# CITY OF ALBUQUERQUE

**Re: Eagle Rock Commons, Building C**  
**5501 Eagle Rock Ave NE**  
**30-Day Temporary Certificate of Occupancy**  
**Transportation Development Final Inspection**  
Engineer's/Architect's Stamp dated 9-23-09(AA)(C18D037H)  
Certification dated 5-21-20

sheet no:
S-1.0

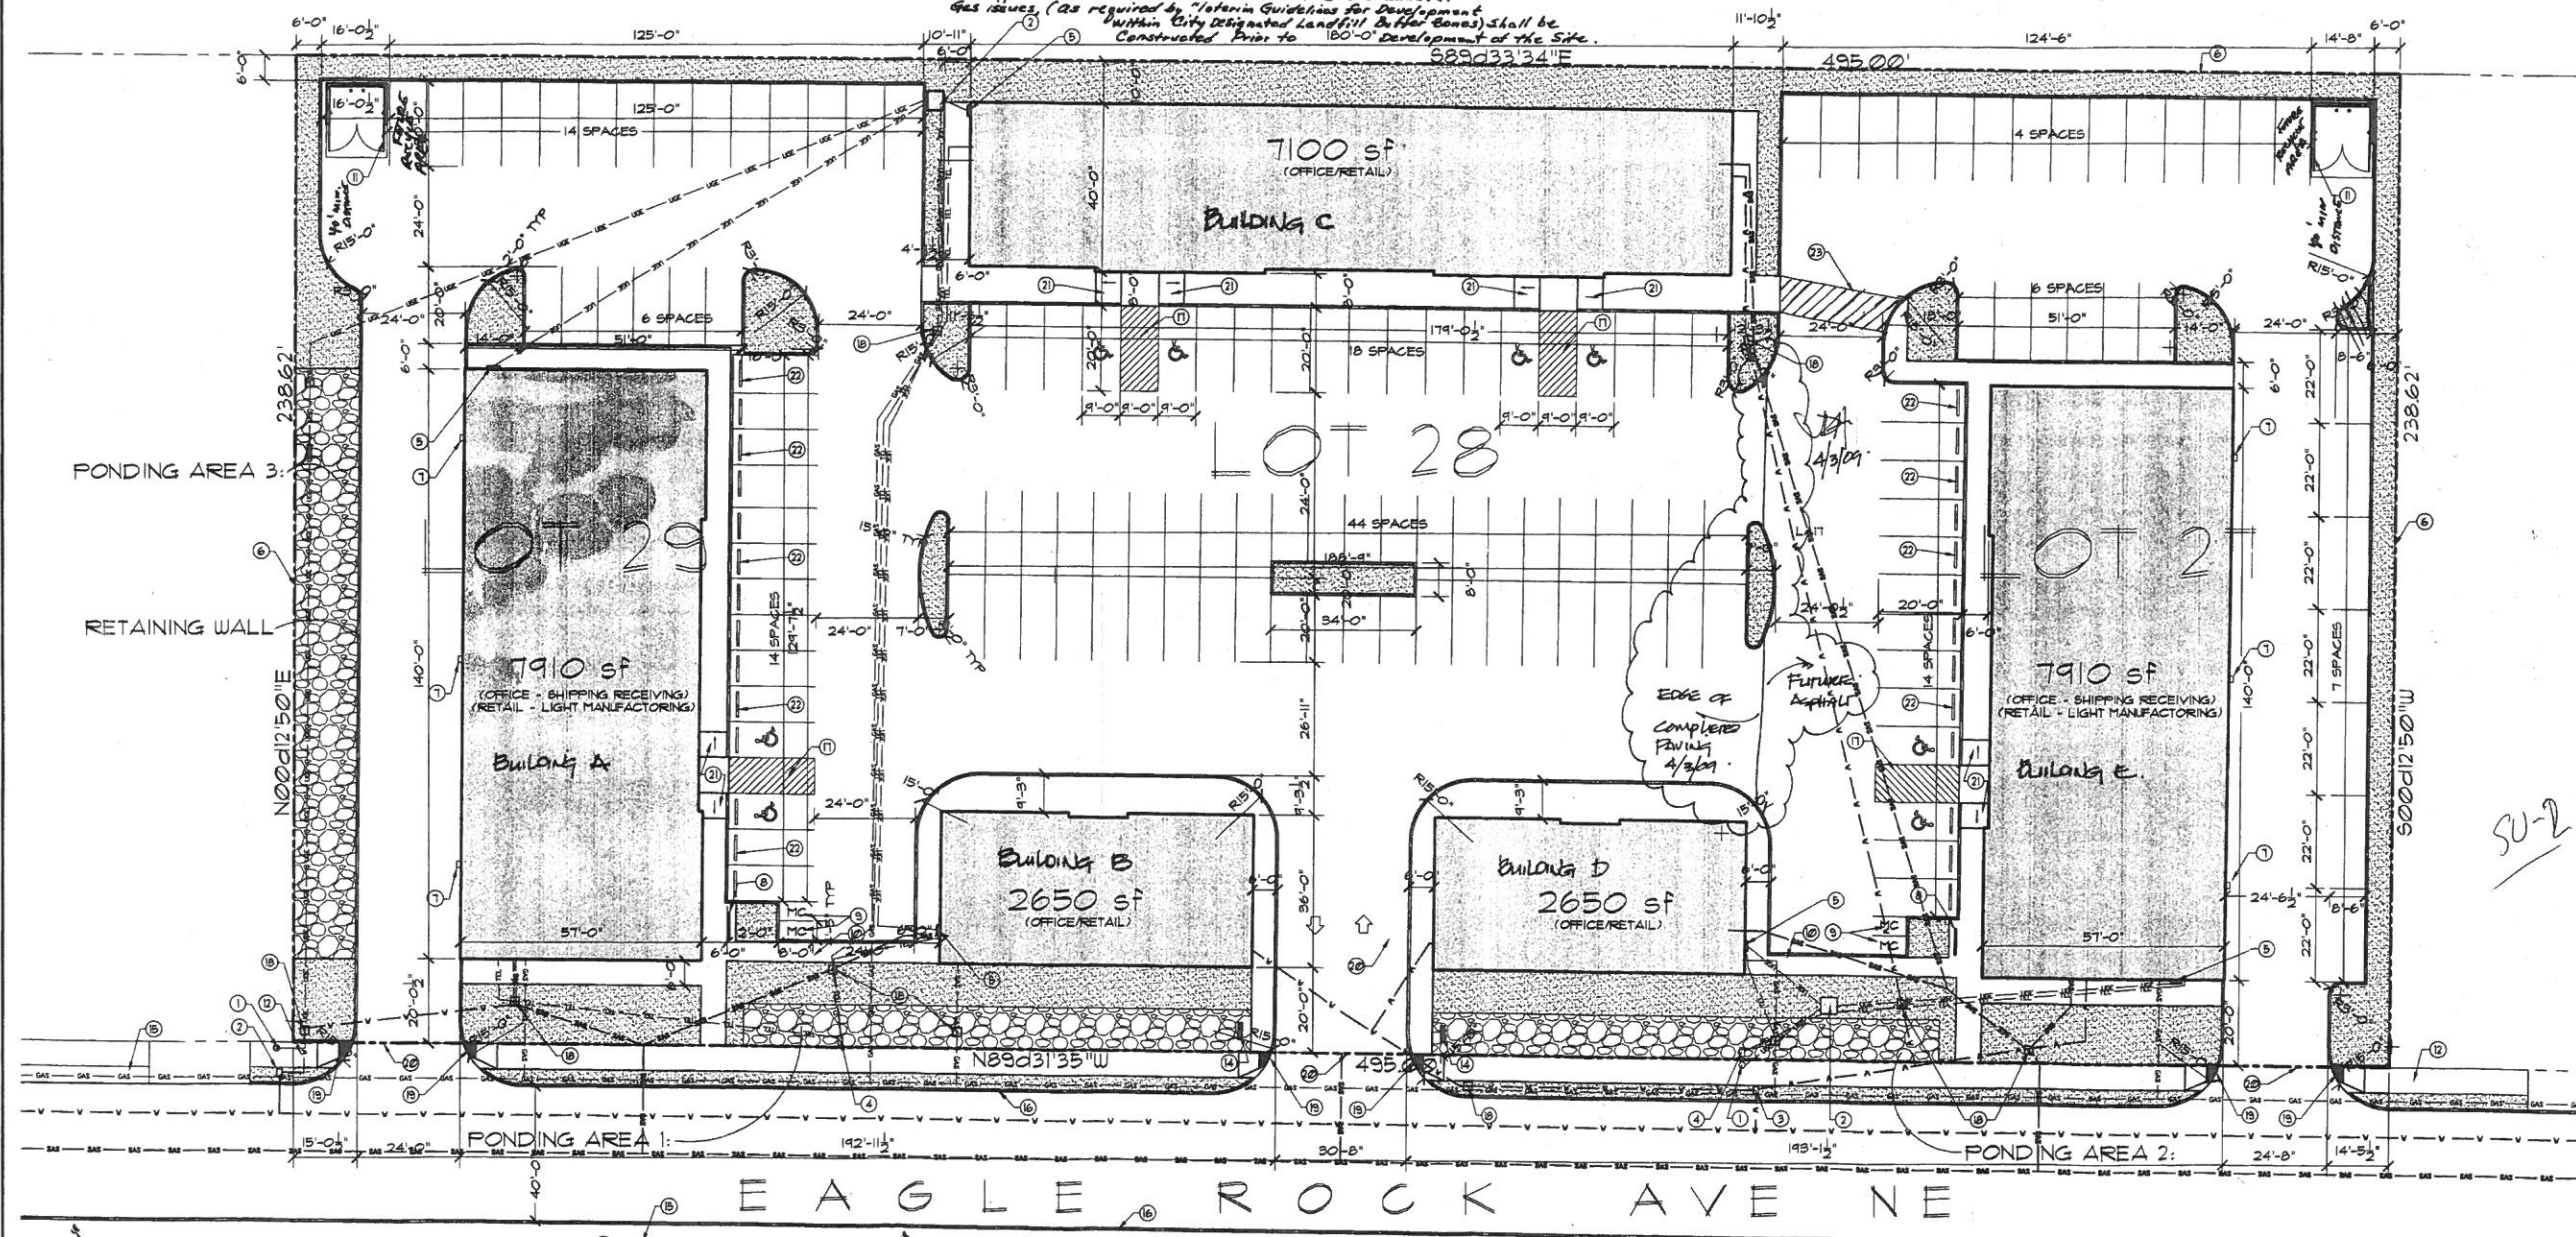
- Please correct raised lip on ADA ramp.
